APPENDIX 1: North Falls Offshore Wind Farm: Environment Agency's Response to the Examining Authority's 2nd Written Questions (ExQ2)

Your Ref: EN010119

Our ref: AE/2025/130509

APPENDIX 2: North Falls Offshore Wind Farm: Environment Agency's comments on [REP4-032] 9.46 Flood Risk Assessment (Clarification regarding flood risk associated with watercourse crossings) - Technical Note, and · [REP4-033] Flood Risk Assessment (Updated NaFRA2 dataset) - Technical Note (Rev 0)

Figure 3.1: Flood Zones

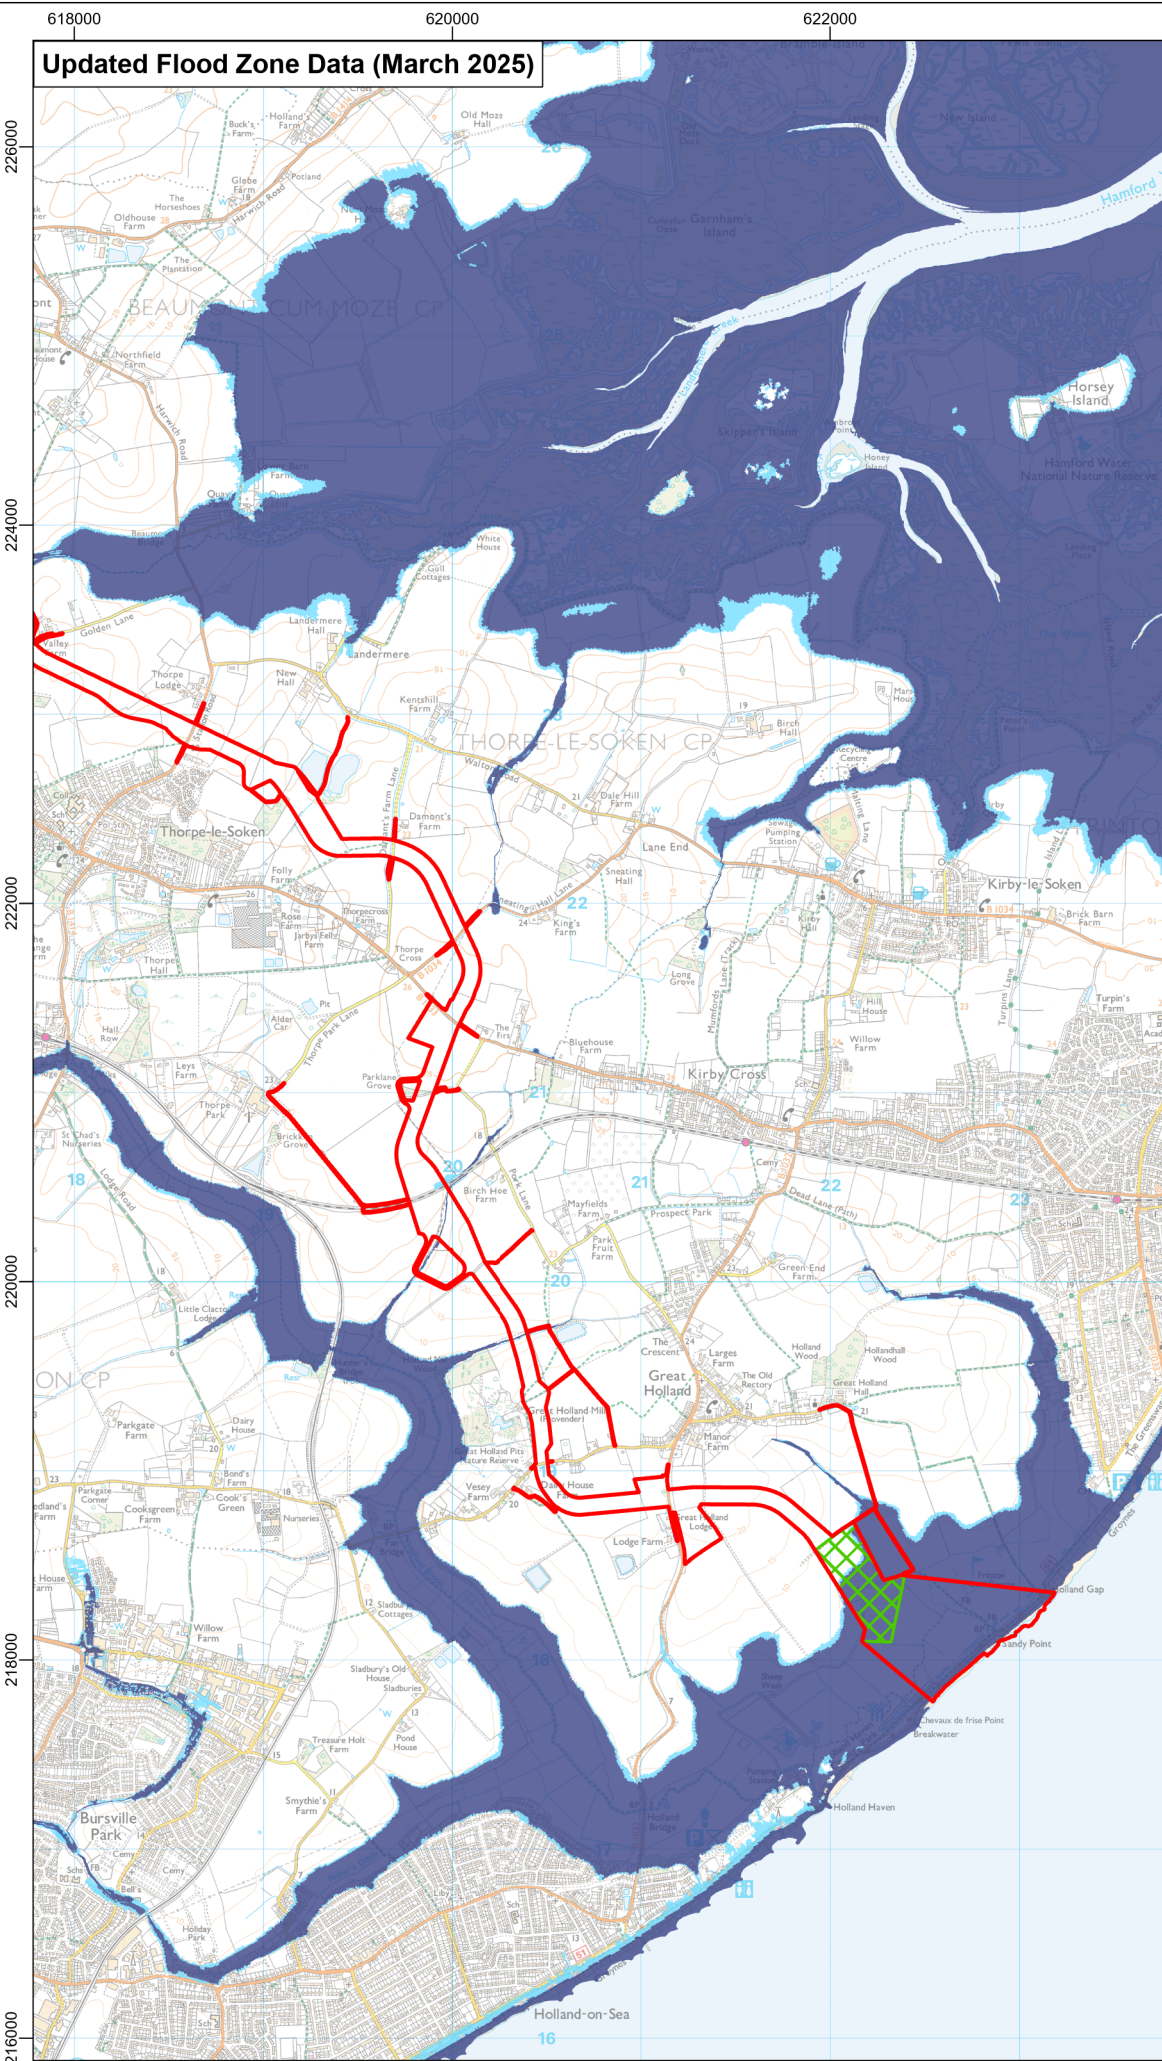
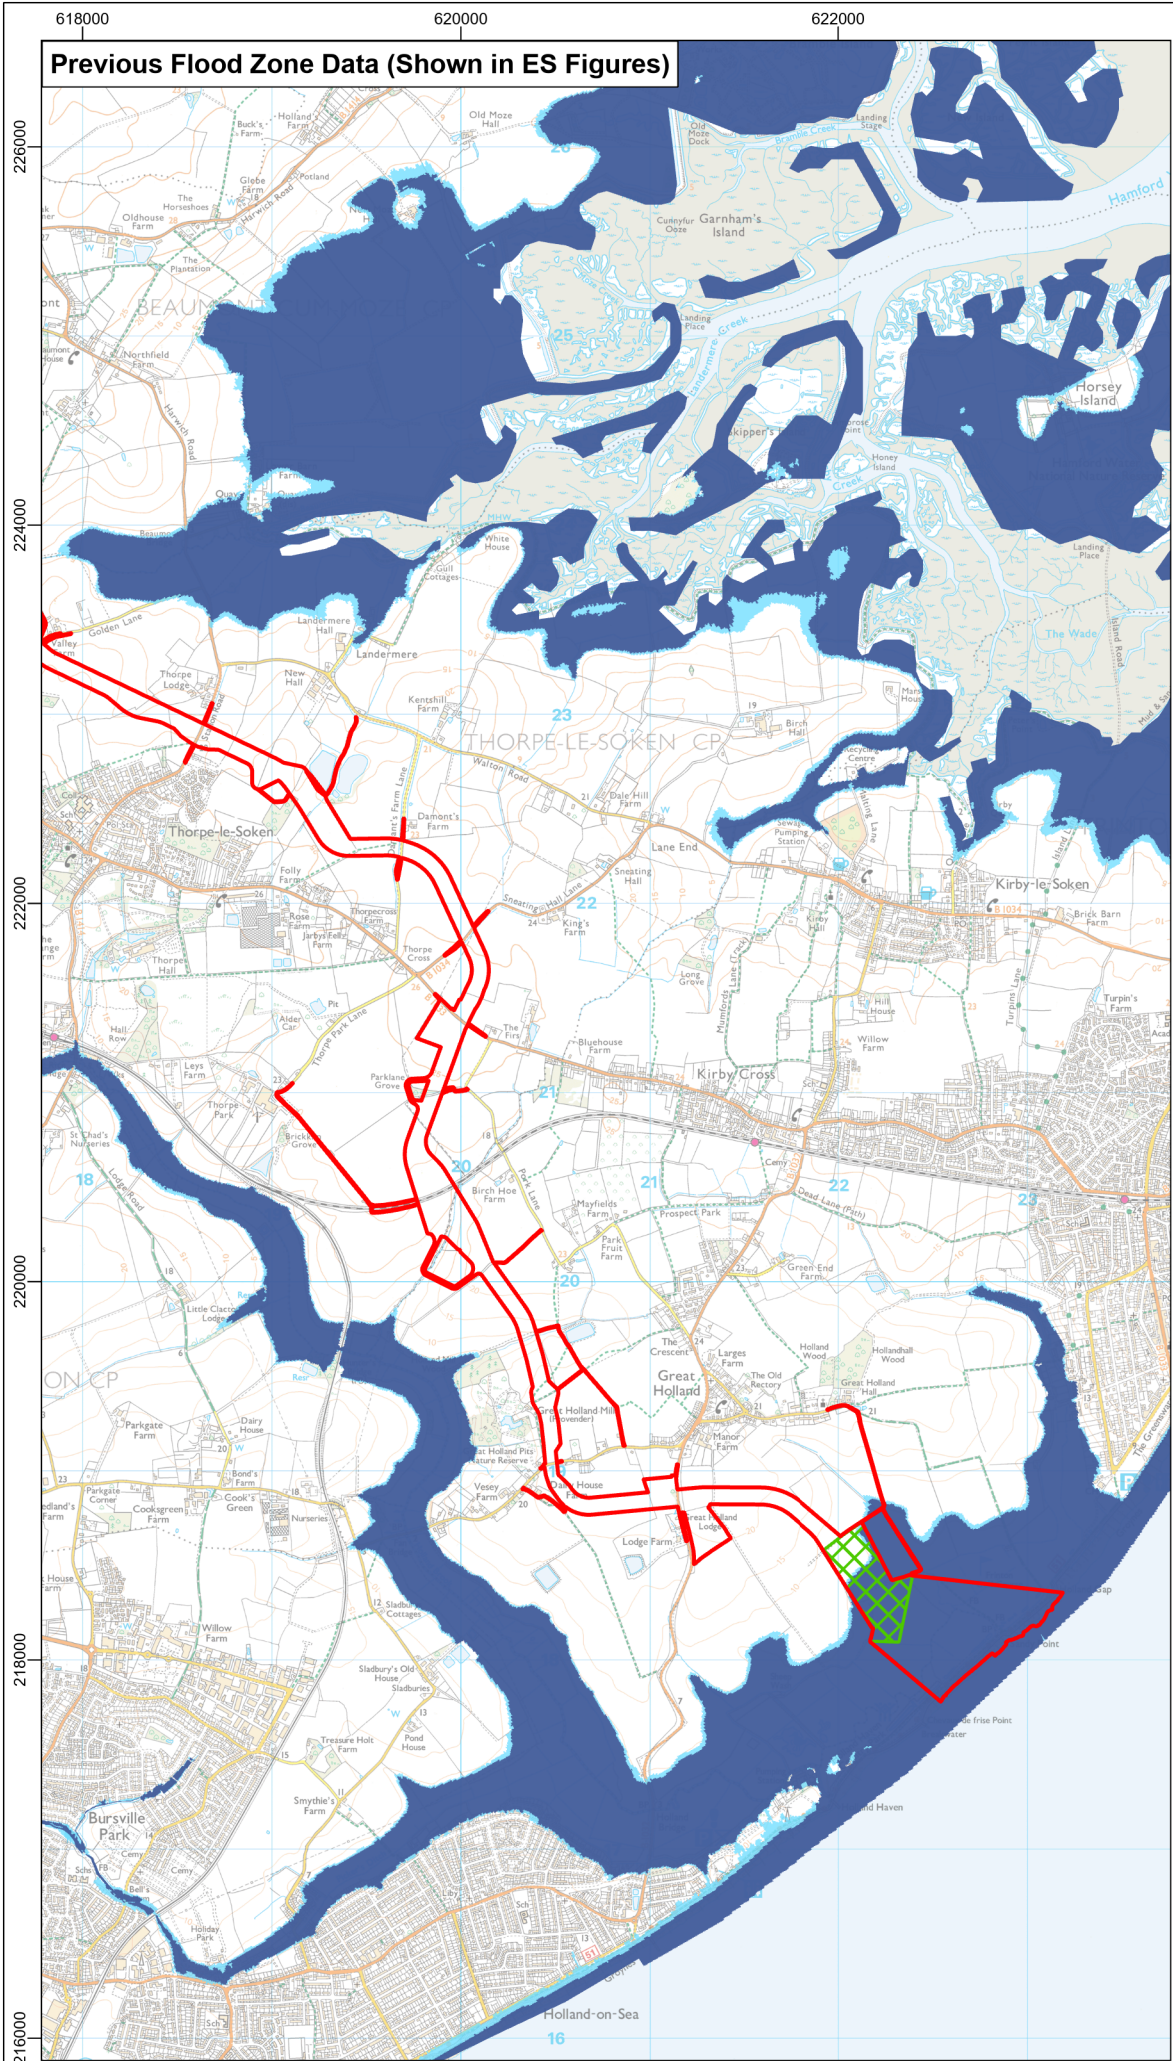
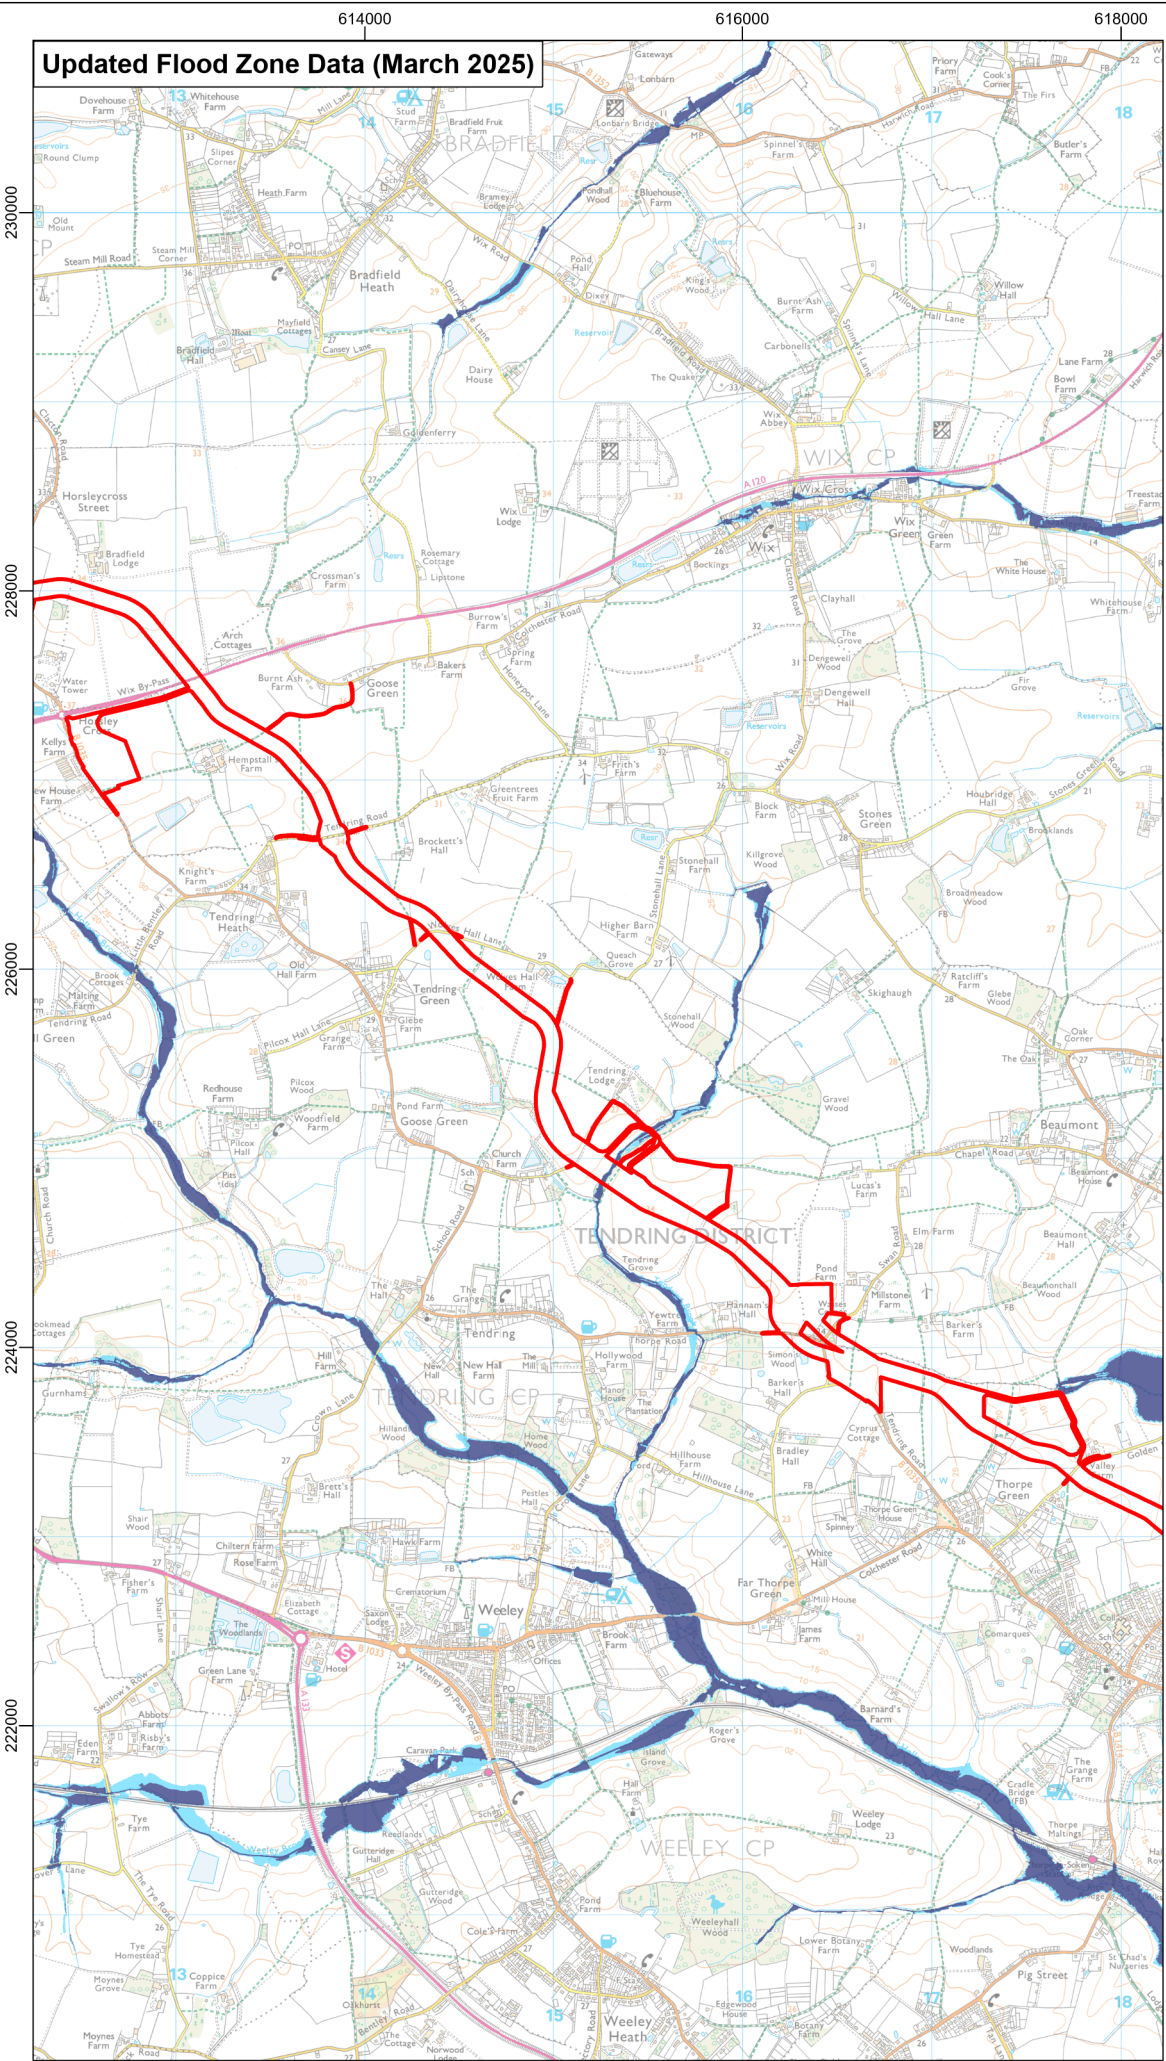
Following submission of the North Falls DCO application in July 2024, the Environment Agency published new national risk information for flooding and coastal erosion. Following a review of the updated Flood Zone extents against previous Flood Zone data used in ES Appendix 21.3 Flood Risk Assessment [APP-121] (see Figure 3.1 and Section 3.1), it is considered that there are no significant changes in the Flood Zone extents across the entire onshore project area. This includes the landfall, onshore cable route and onshore substation works area.
